TfNSW Reference: SYD20/01213/03 Departments Reference: SSD-10101987

EXHIBITION OF EIS - KEMPS CREEK DATA CENTRE - 709-769 MAMRE ROAD, KEMPS CREEK

Attachment A

- Legend**
- Body Envelope
 - 300mm Envelope
 - 600mm Envelope
 - Wheel Envelope

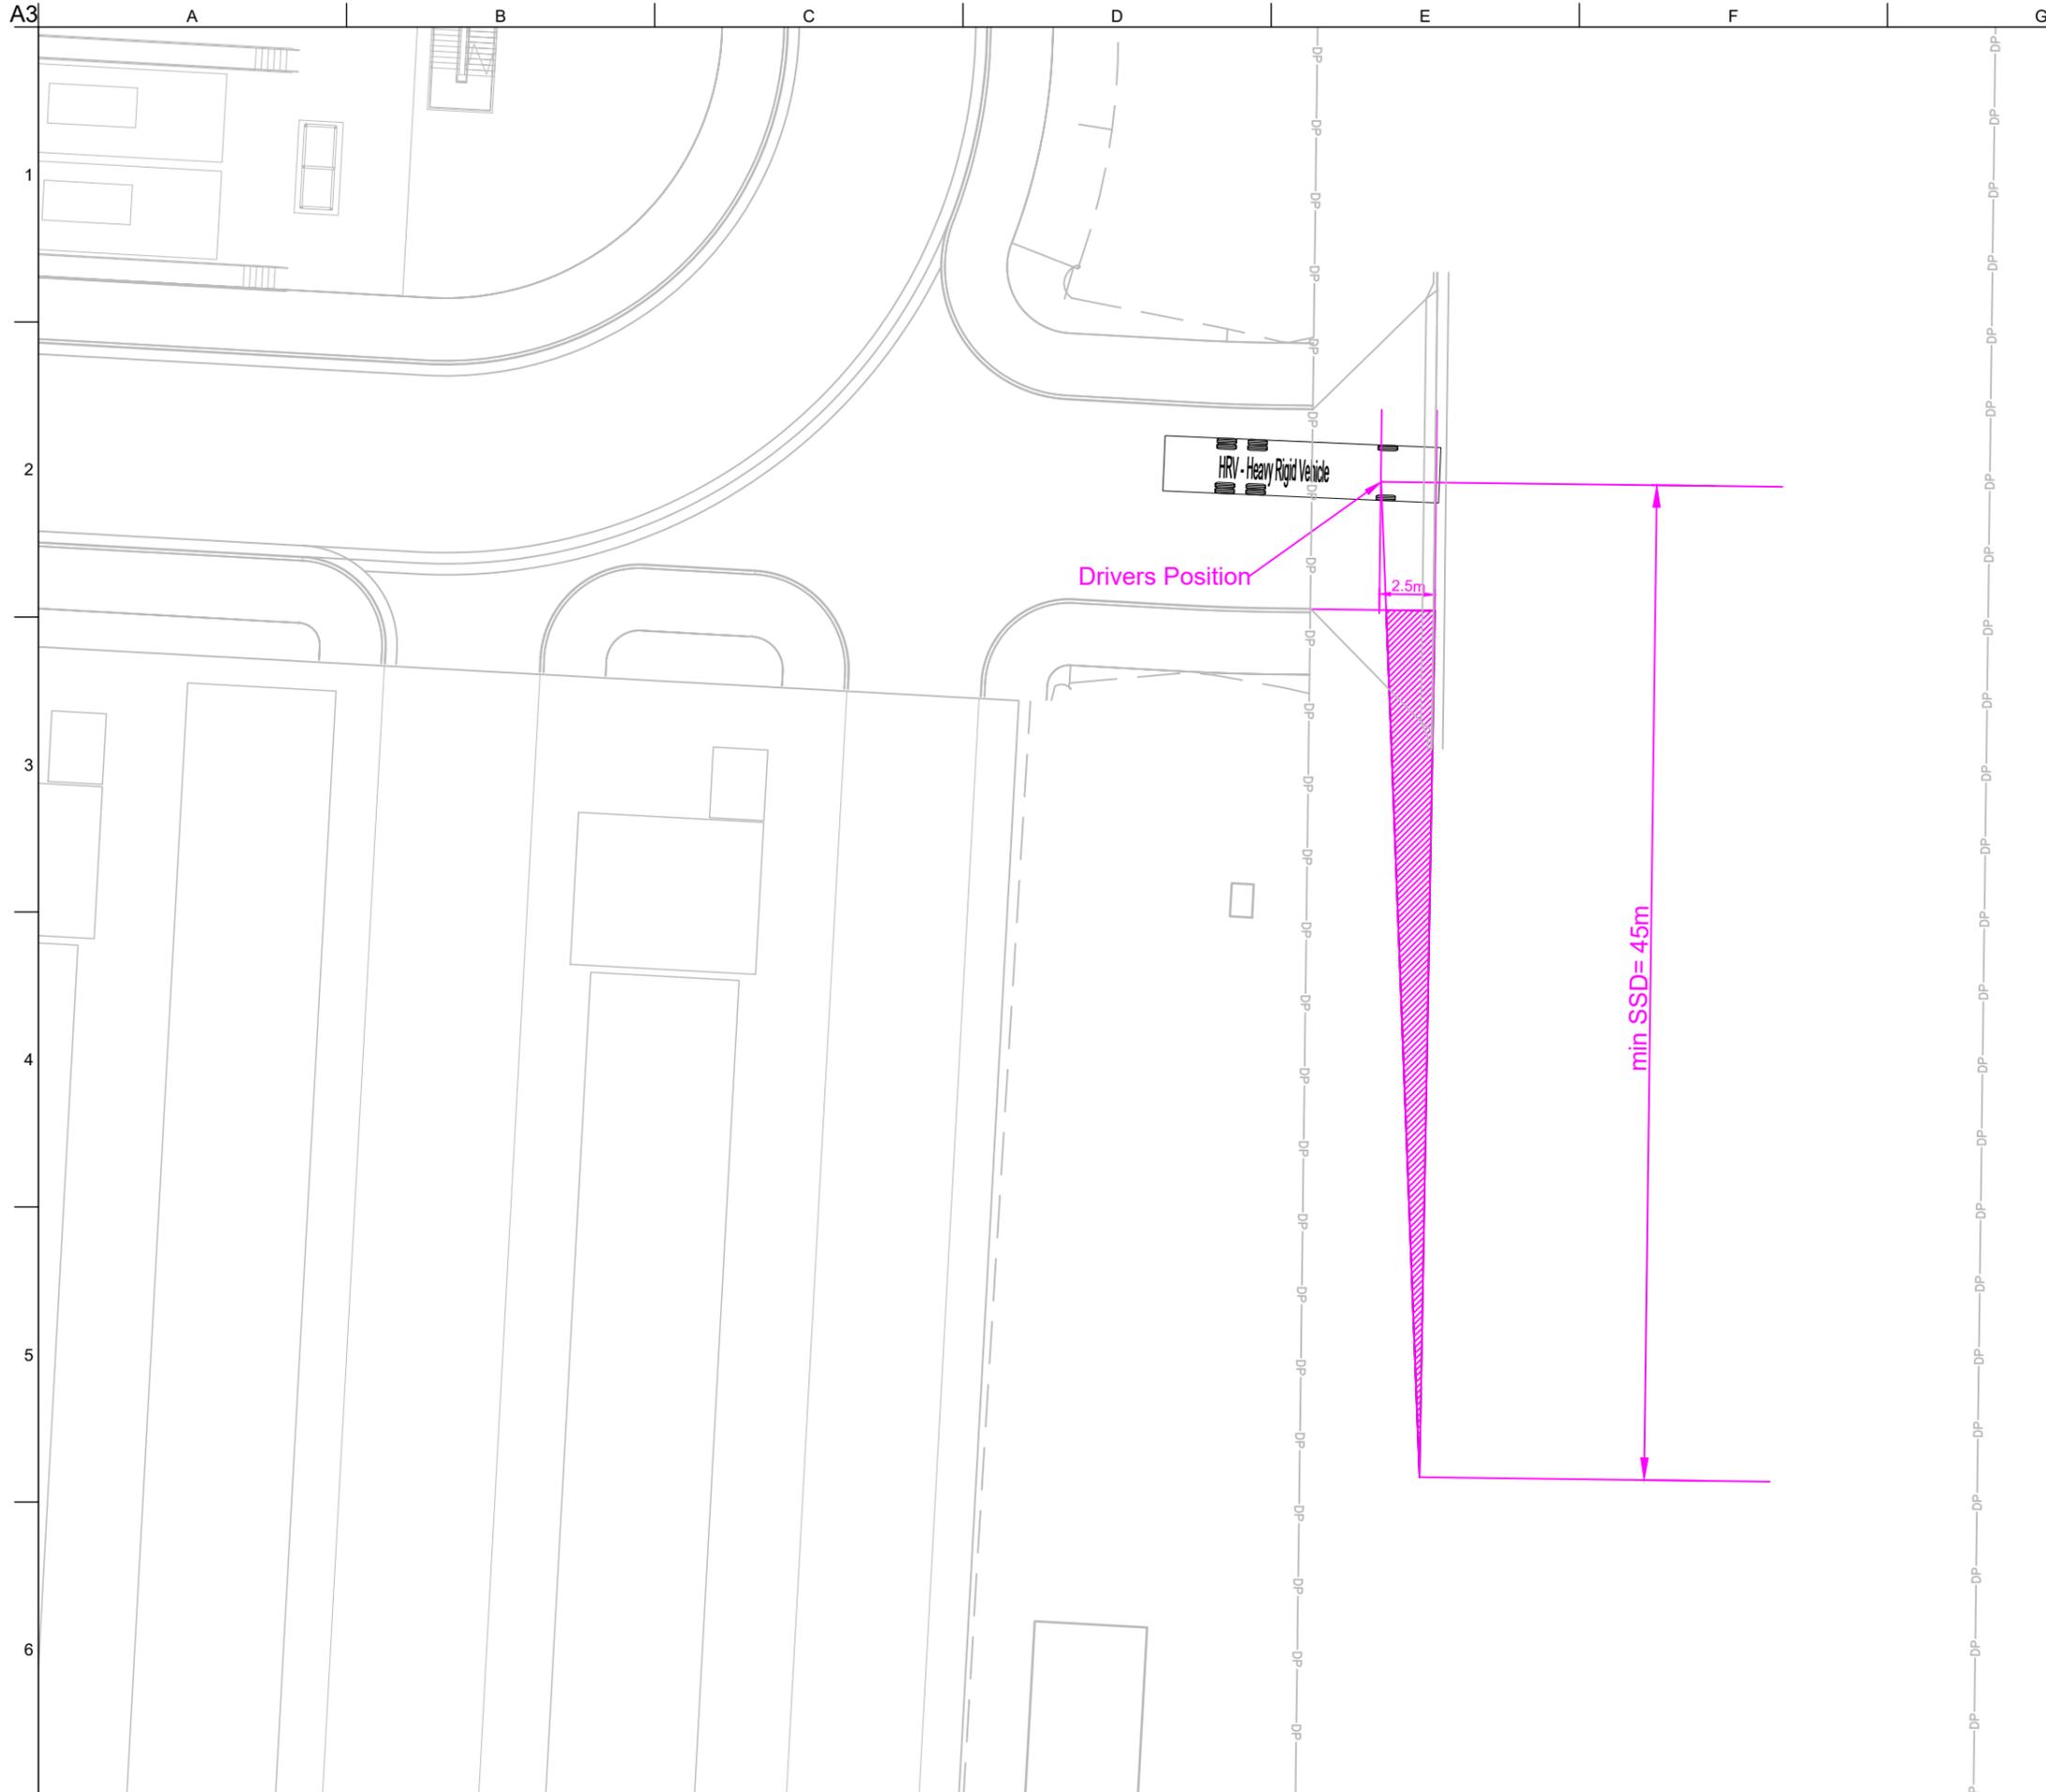
Appendix B – *Technical Drawings* – The swept path plans are provided for a 19 metres Articulated Vehicle. However as mentioned above, according to the Mamre Road Precinct DCP Table 13, it should be tested for 30m PBS Level 2 Type B vehicle.

It is recommended that the swept path plans be provided to reflect the Mamre Road Precinct DCP requirements.
